Address: Wood View Farm Birkby Road Huddersfield HD2 2DN

Application number: 2024/92647	
What is the application for?:	Erection of detached dwelling with detached garage
Address of the site or building:	Land at Occupation Lane, off Birkby Road, Huddersfield, HD2 2ES
Postcode:	HD3 4EY

Drawing title
**Garage Floor Plan and Elevations as
Proposed**

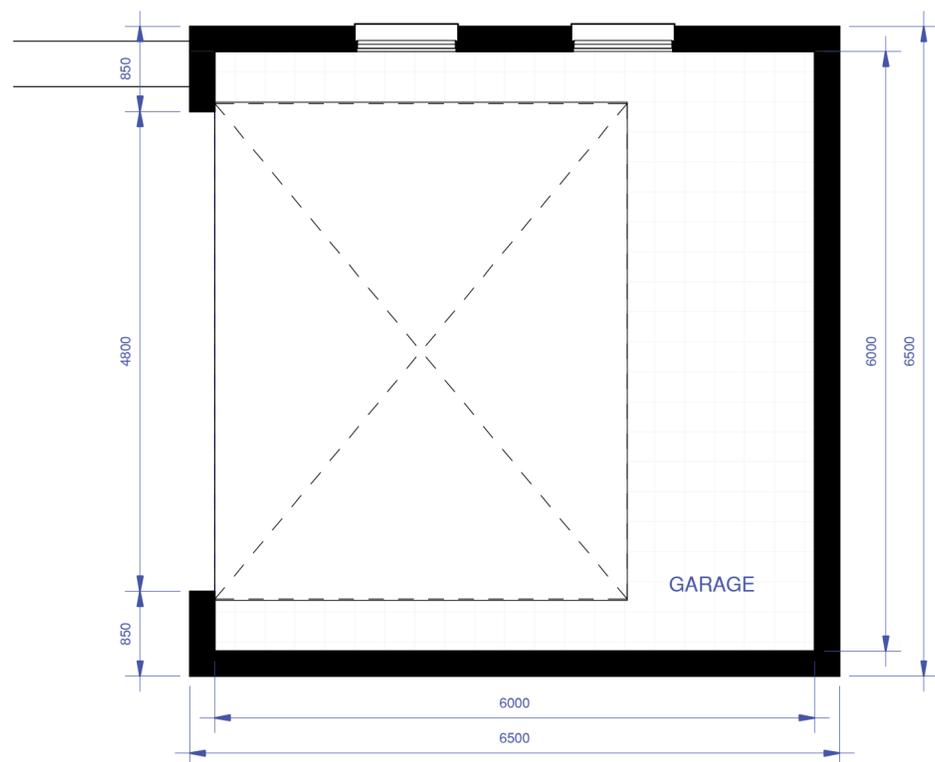
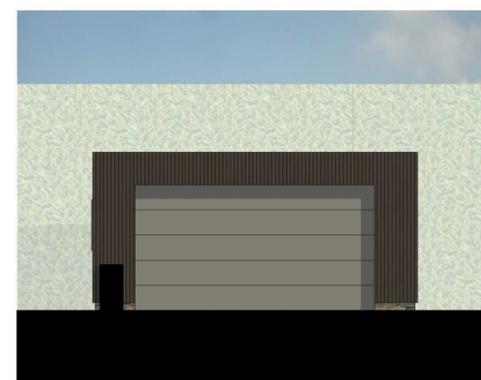
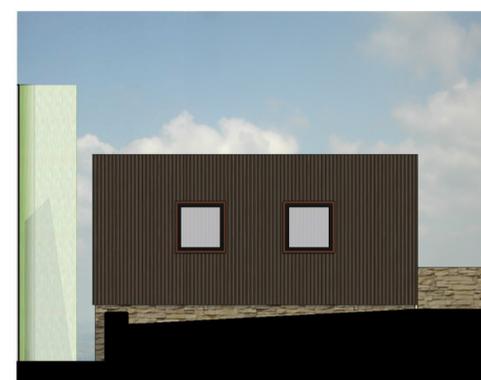
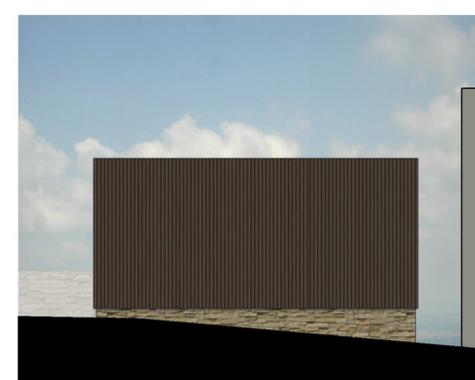
The proposed siting of both the bungalow and garage, close to property boundaries, leaves inadequate space for essential construction equipment and activities. The lack of space for scaffolding, machinery, and vehicle movement will likely cause damage to boundary features, such as dry stone walls, and may lead to further trespass onto neighbouring properties. This impractical and constrained layout poses risks of physical damage and fails to respect the rights and amenity of neighbouring landowners.

The proposed development is incongruous with the existing character of the neighbourhood. Its design—a flat-roofed bungalow placed immediately adjacent to property boundaries—fails to integrate with the surrounding built environment or to maintain the area's aesthetic integrity. Such a design would contribute to a visually disruptive and cramped development, contravening Policy LP24(a) of the Kirklees Local Plan and Chapter 12 of the National Planning Policy Framework. Additionally, the planned removal of the dry stone wall, a distinctive feature of the area, would further erode the unique character of our locality.
